Response to RPA Hospital Multi-storey Staff Carpark (SSD 7542)

I am a long term resident owner of a Church St property two blocks north of the proposed development, and a frequent pedestrian, bicycle and vehicular traveller in the local area.

EXTERNAL WORKS PLAN

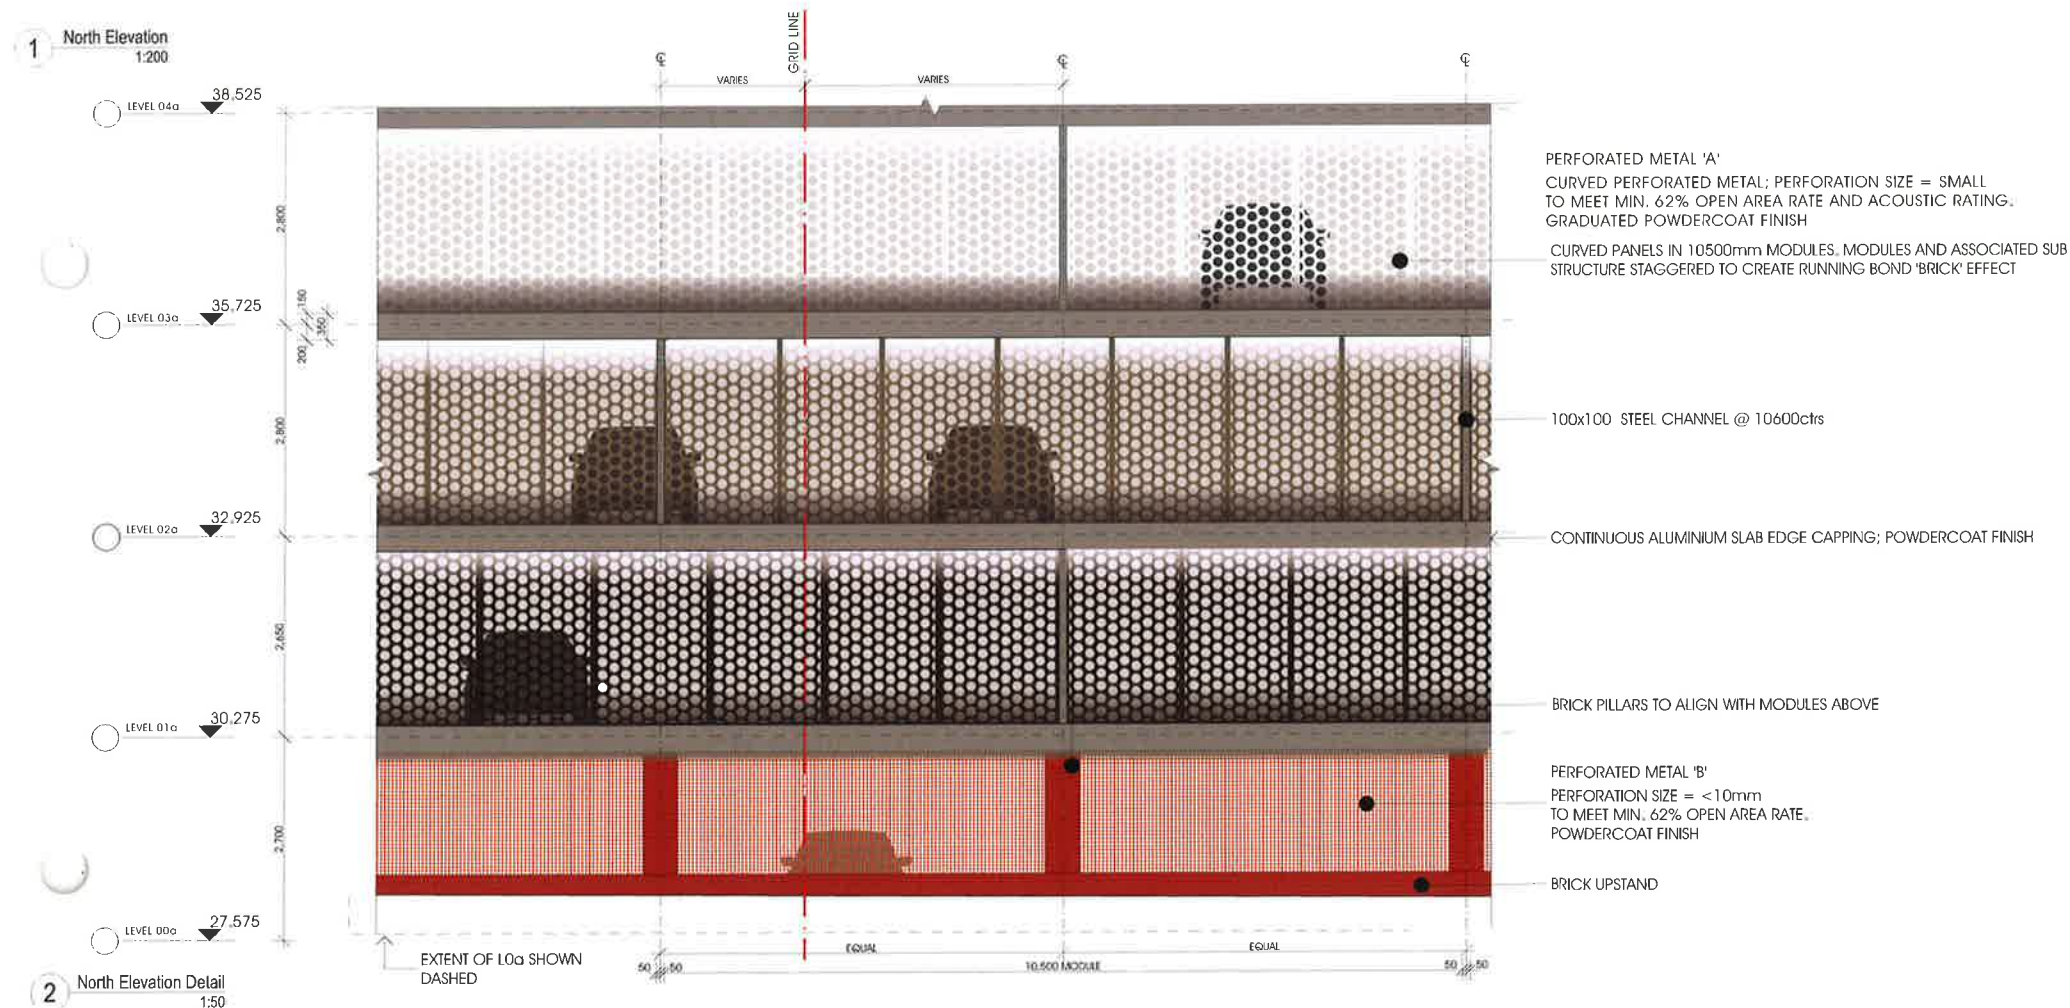
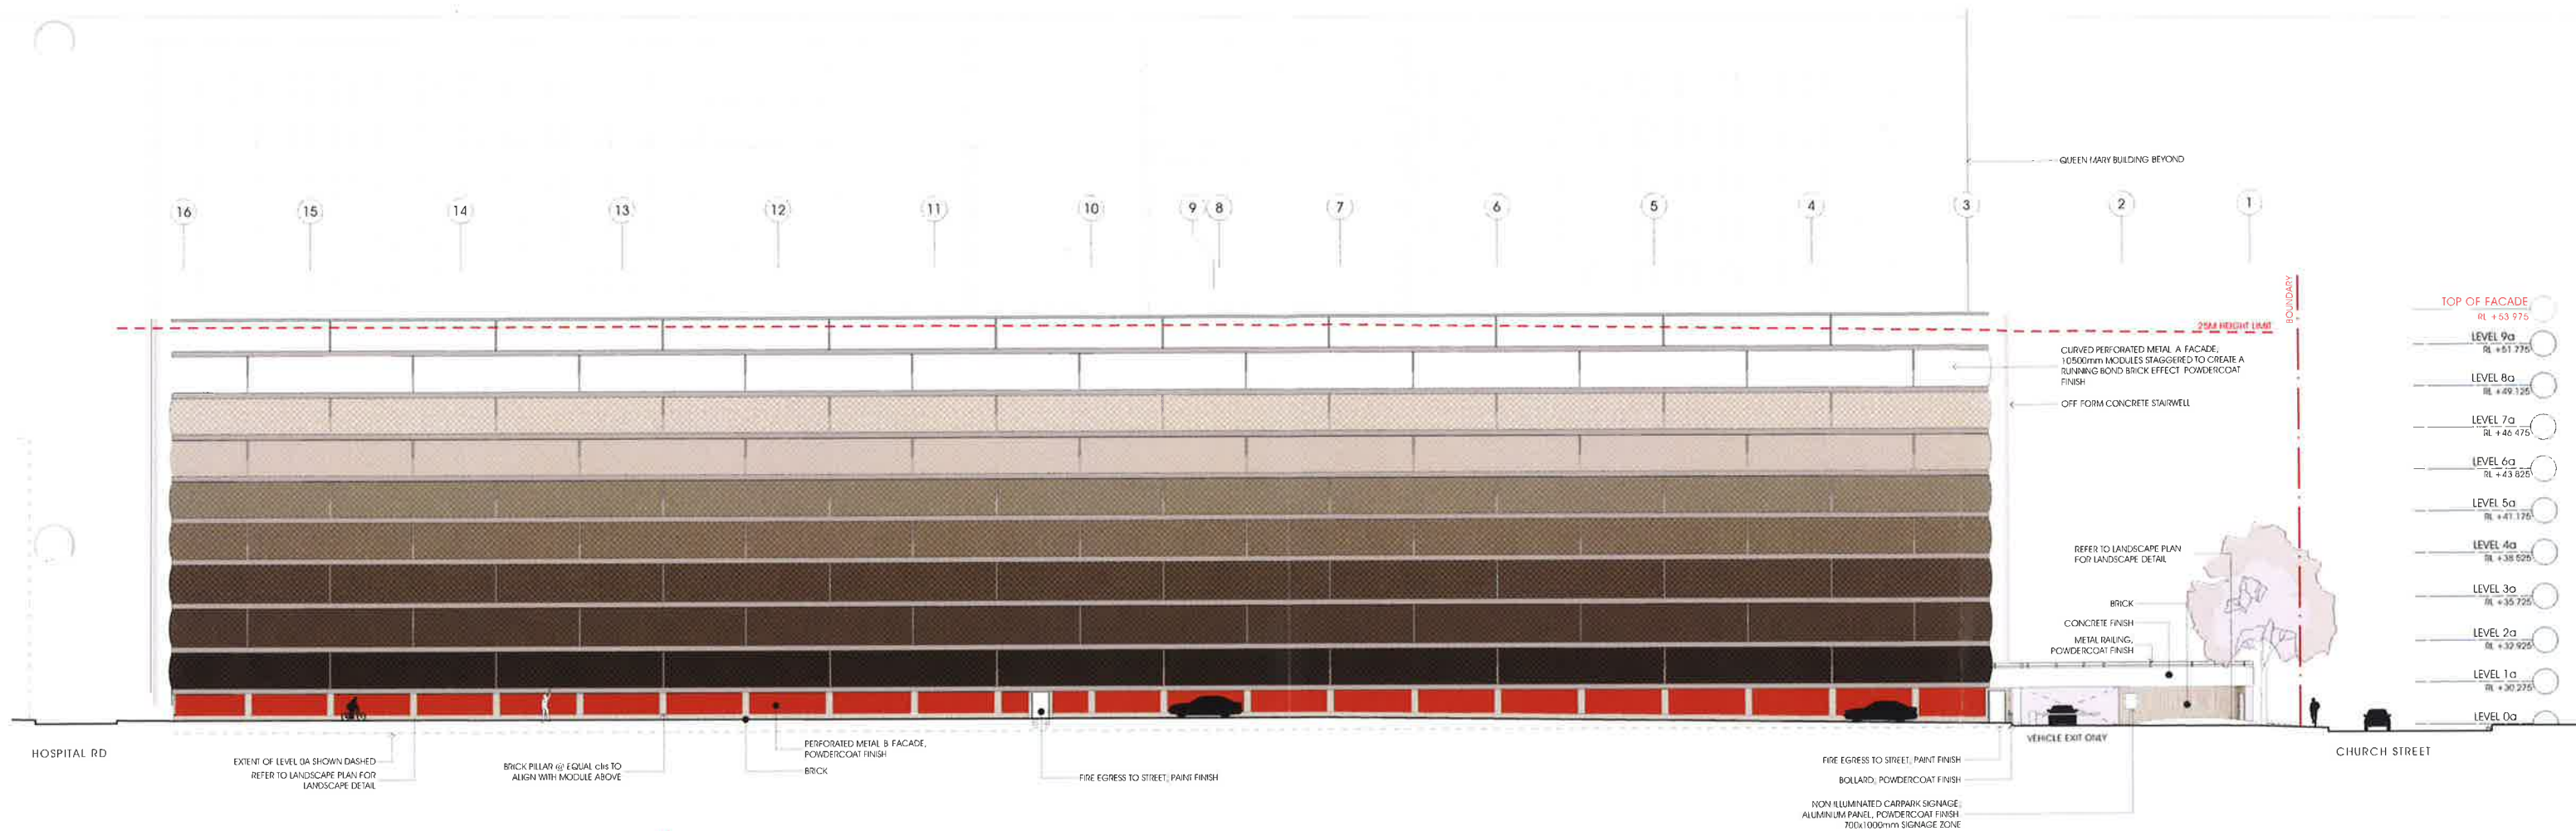
The proposal discharges vehicles from a western exit across the footpath into Church St. The ~1.2m wide bitumen footpath shown in the Architectural Drawings [3] is incorrect. The footpath has been widened to 5.5m and is now concrete with garden beds, to improve pedestrian amenity. The width of Church St has consequently been reduced.

I object to vehicles crossing a 5.5m footpath into a narrowed street with a reduced vehicle turning curve on the grounds of functionality, pedestrian safety, and traffic flow.
